V:\52876\active\187608744-Mule Deer\CAD\Sheets\Construction Drawings\27 - Grading And Erosion Control Plan.dwg  
 2019/02/27 6:36 PM By: Durham, Charlene

THE GARDENS AT NORTH CAREFREE GRADING & EROSION CONTROL PLAN		
Designer: CD	Structure Numbers	Project No./Code 187608744
Detailer: MB		
Sheet Subset:		SHEET 27 OF 31

THE GARDENS AT NORTH CAREFREE
 GRADING & EROSION CONTROL PLAN

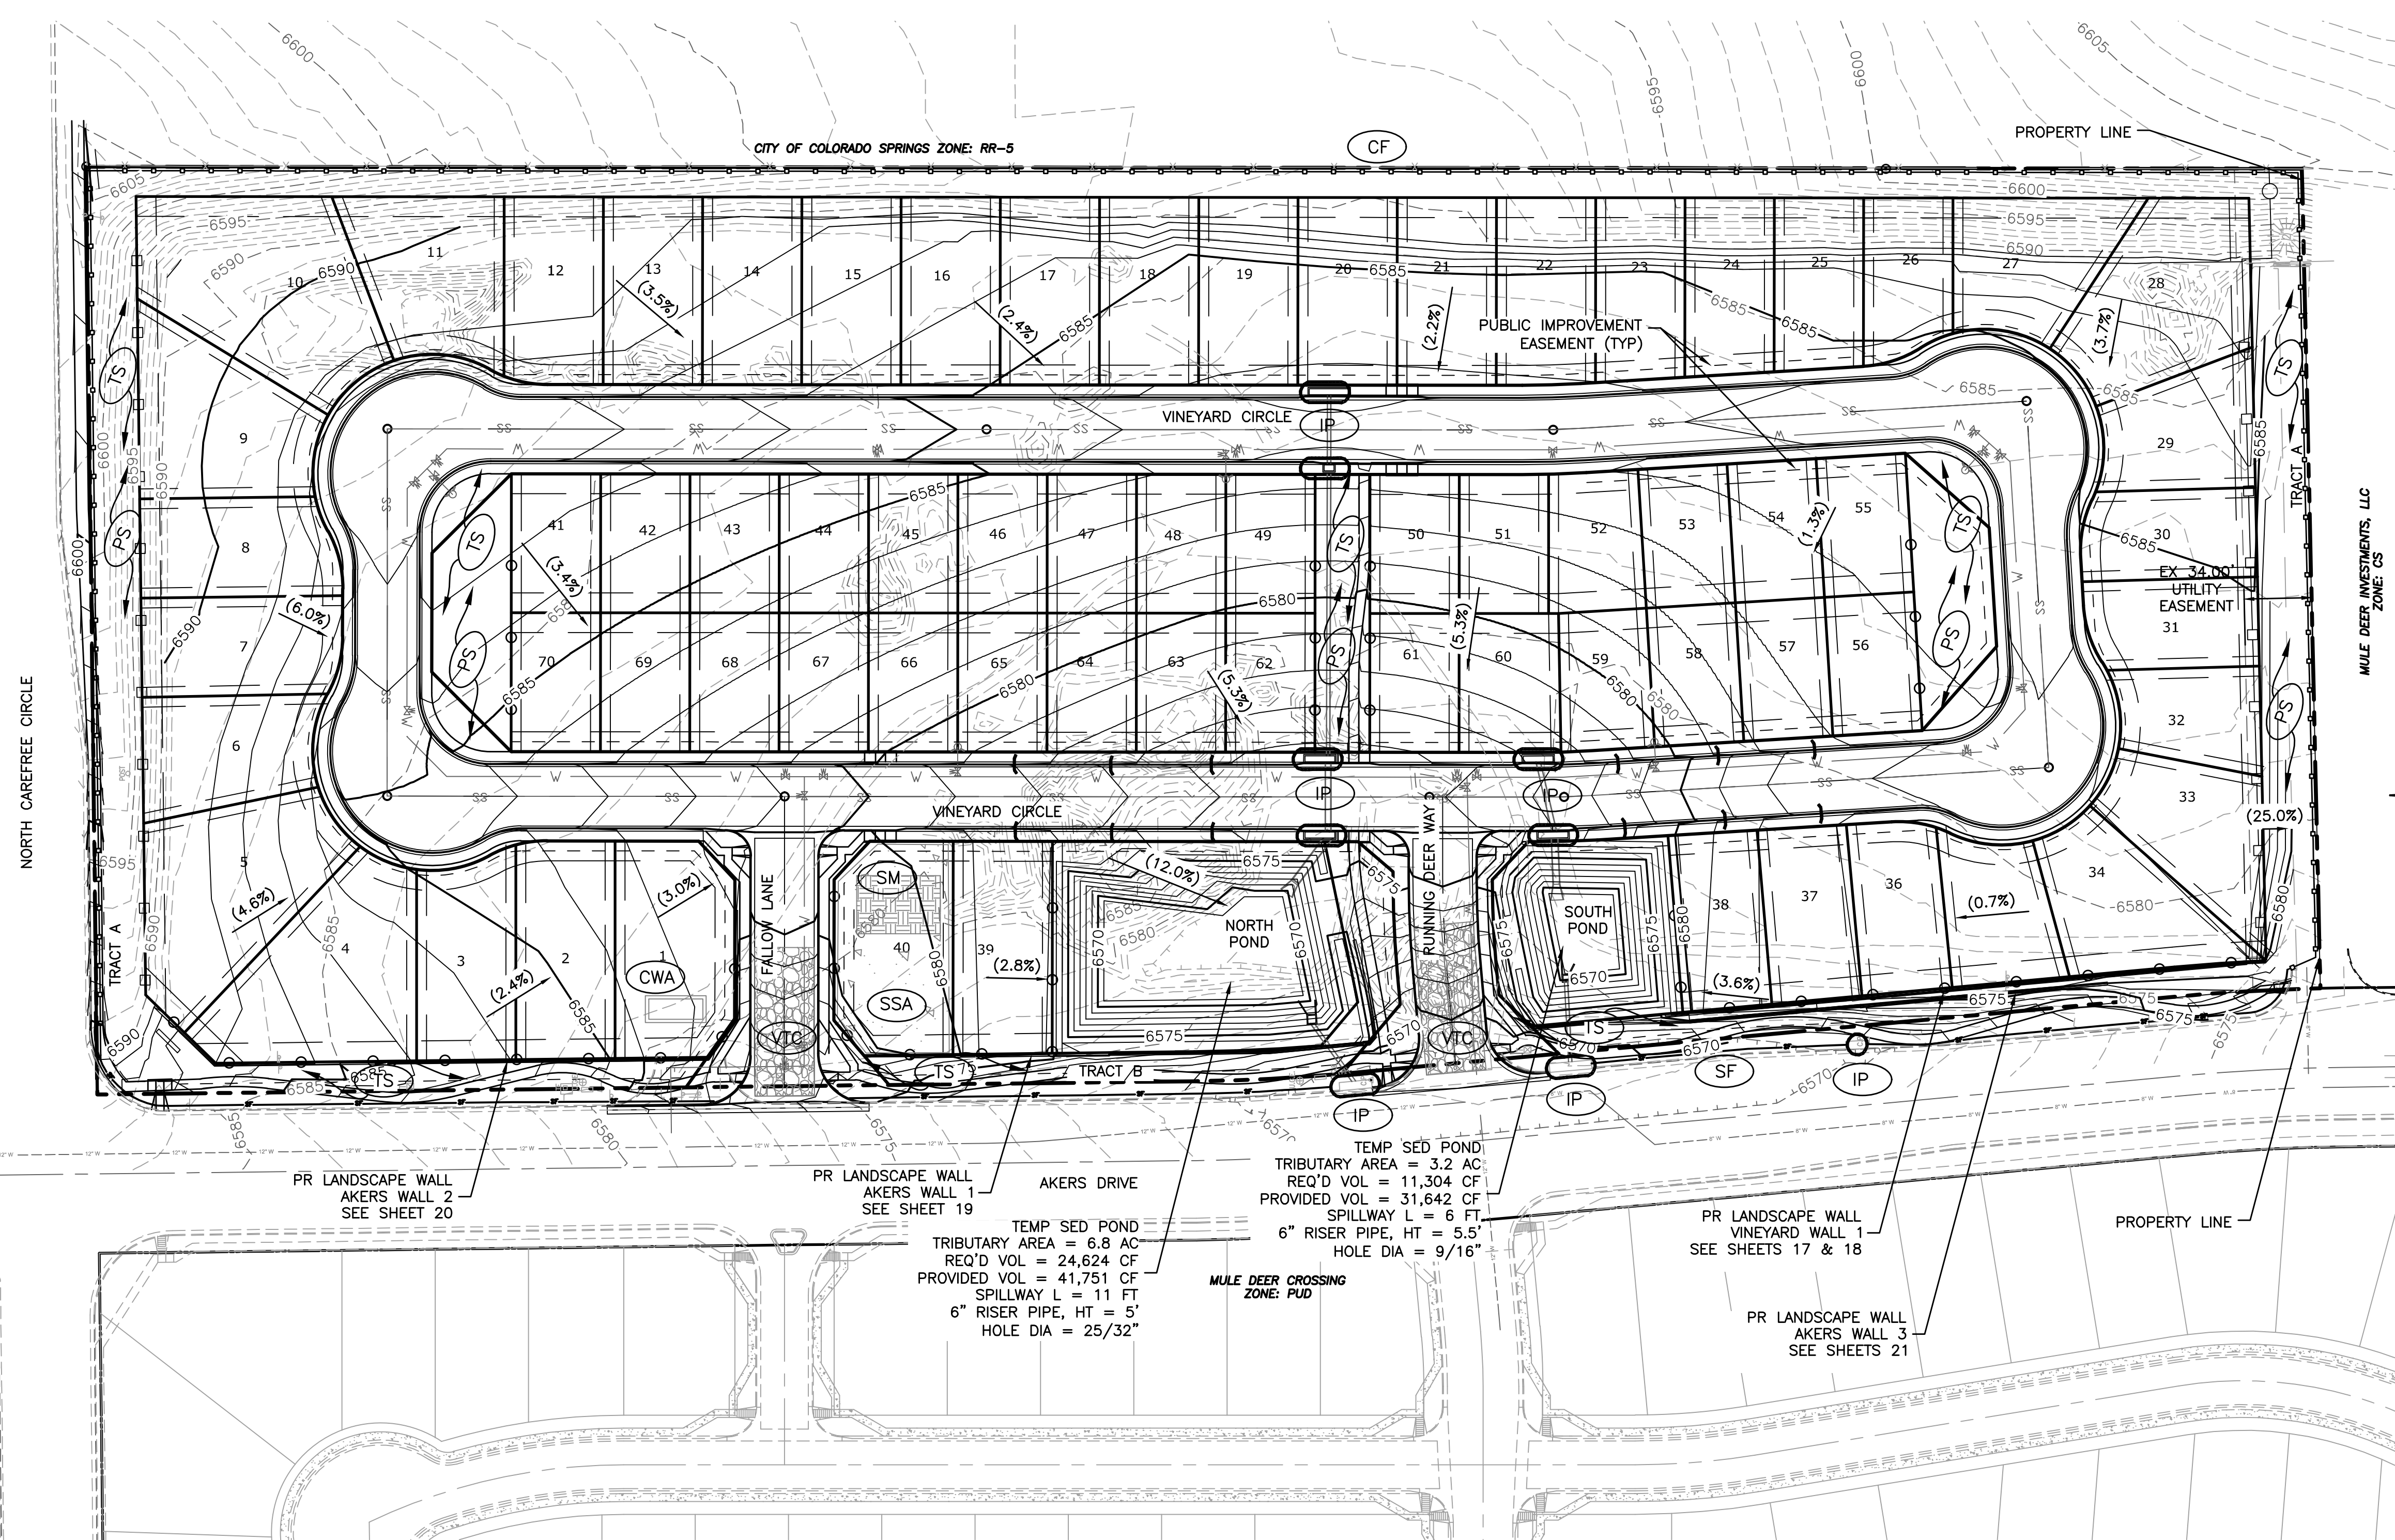
Please remove the signature blocks from this sheet. The Grading and Erosion control plans will be approved with the complete construction plan set. Refer to construction plans for redlines/comments
